From: [REDACTED]
Sent: 10 October 2017 13:40
To: Planning
Subject: Planning application 6/2017/2160/COND - Mercury House

Mercury House
1 Broadwater Road
Welwyn Garden City
AL7 3BQ

Submission of details pursuant to condition 1 (materials samples), 2 (soft and hard landscaping), 6 (bin stores) and 7 (cycle stores) on planning permission 6/2016/2624/FULL, dated 14/09/2017

Drawing  
Proposed Cycle Store

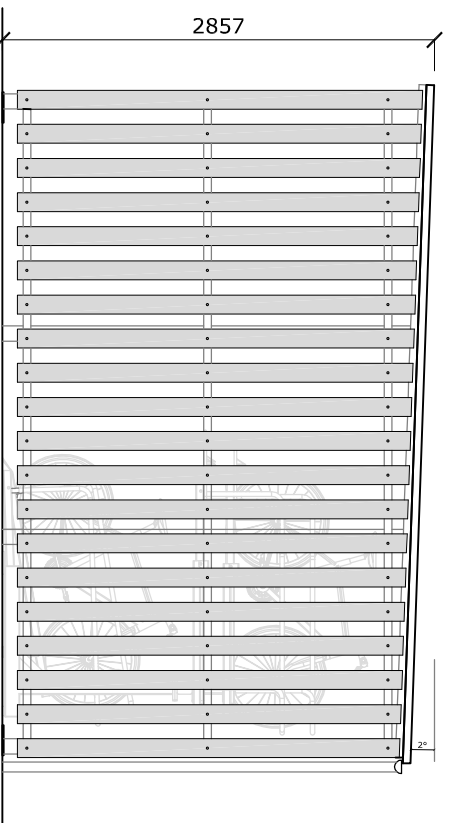
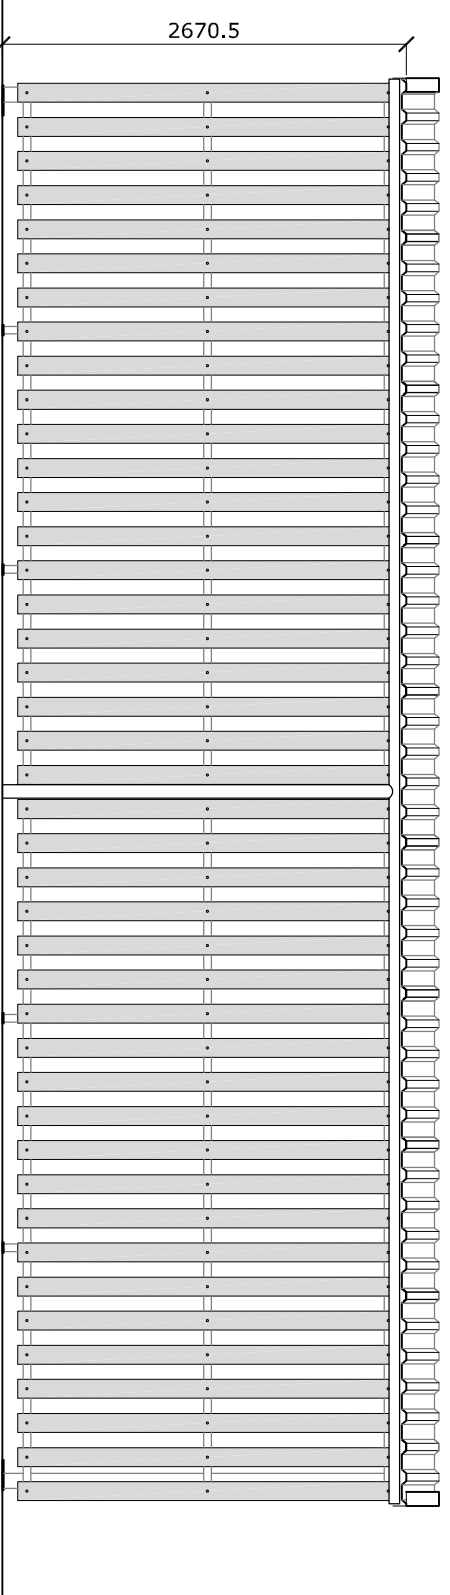
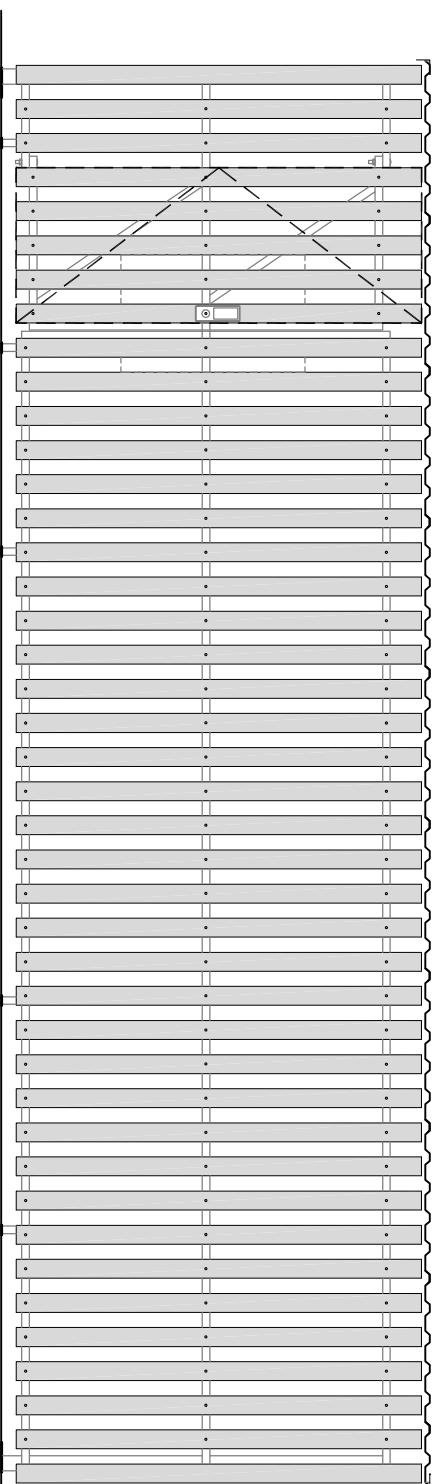
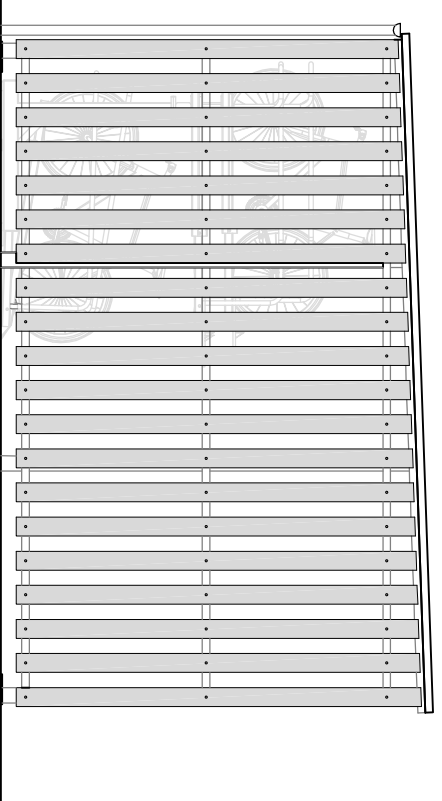
HCC are supportive of the provision of the cycle parking. The change of use provided 43 residential units (HCC commented to application 6/2016/2624/FULL in our response dated 23/01/17).

Width of store provides suitably for the level of parking proposed, utilising 2 tier cycle storage, with sufficient space clear behind bays to enable bays to be locked. The site is close to cycle routes including routes adjacent to A1000 as well as NCN61B, and shall support non-car based journeys.

HCC would suggest that the details are acceptable.
